WILBUR E. DEES, P.E., P.L.S.  
CONSULTING ENGINEERING AND LAND SURVEYING  
1100 CLARENDON STREET, SUITE 101  
FAYETTEVILLE, N. C., 28305  
CELL PHONE (910) 624-4779  
E-MAIL: [WED7111@GMAIL.COM](mailto:WED7111@GMAIL.COM)

AUGUST 15, 2023

RE: MR. LONNIE WALKER  
8600 LOOKING GLASS ROAD  
LINDEN, NORTH CAROLINA 28356

THE DETACHED LIGHT STEEL ACCESSORY BUILDING PIN #0555 07 1231, HARNETTE COUNTY, WAS CONSTRUCTED WITH OUT A BUILDING PERMIT AND NO BUILDING INSPECTIONS REQUESTED.

### CONCRETE MONOLITHIC SLAB BASE RAIL ANCHORAGE

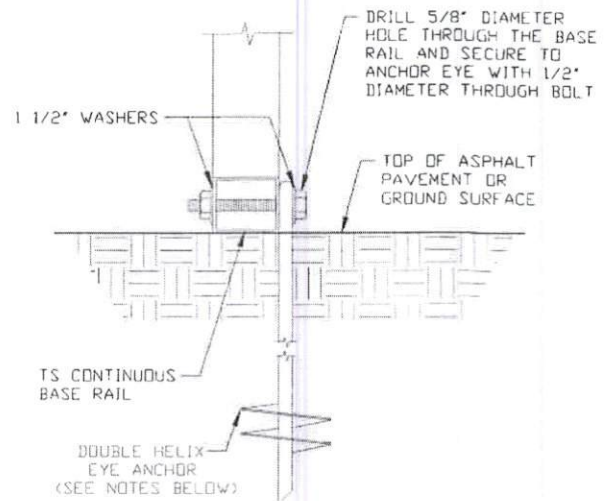
BASED UPON MY PREVIOUS SITE VISIT AND INSPECTIONS OF THE ABOVE REFERENCED LIGHT STEEL ACCESSORY BUILDING'S CONCRETE FLOOR SLAB IT HAD NO INTERGAL CONCRETE FOOTING.

I RECOMMENDED TO THE CONTRACTOR TO ADD ADDITIONA CONCRETE TO THE EXISTING FLOOR SLAB TO OBTAIN AN INTERGAL TURN-DOWN FOOTING WITH IT'S BOTTOM OBTAINING THE REQUIRED BUILDING CODE REQUIREMENT OF 12 INCHES BELOW FINISH OUTSIDE GRADE.

THIS WILL REQUIRE THE CONTRACTOR TO EXCAVATE DOWN BESIDE THE CONCRETE FLOOR SLAB ON ALL FOUR SIDES 8 INCHES WIDE, 12 TO 18 INCHES DEEP AND EXTEND 12 INCHES UNDER THE EXISTING FLOOR SLAB.

SOME AREAS WHERE THE OUTSIDE GRADE HAS BEEN ERRODED THE NEW INTERGAL FOOTING WILL REQUIRE SOME WOOD FORMING.
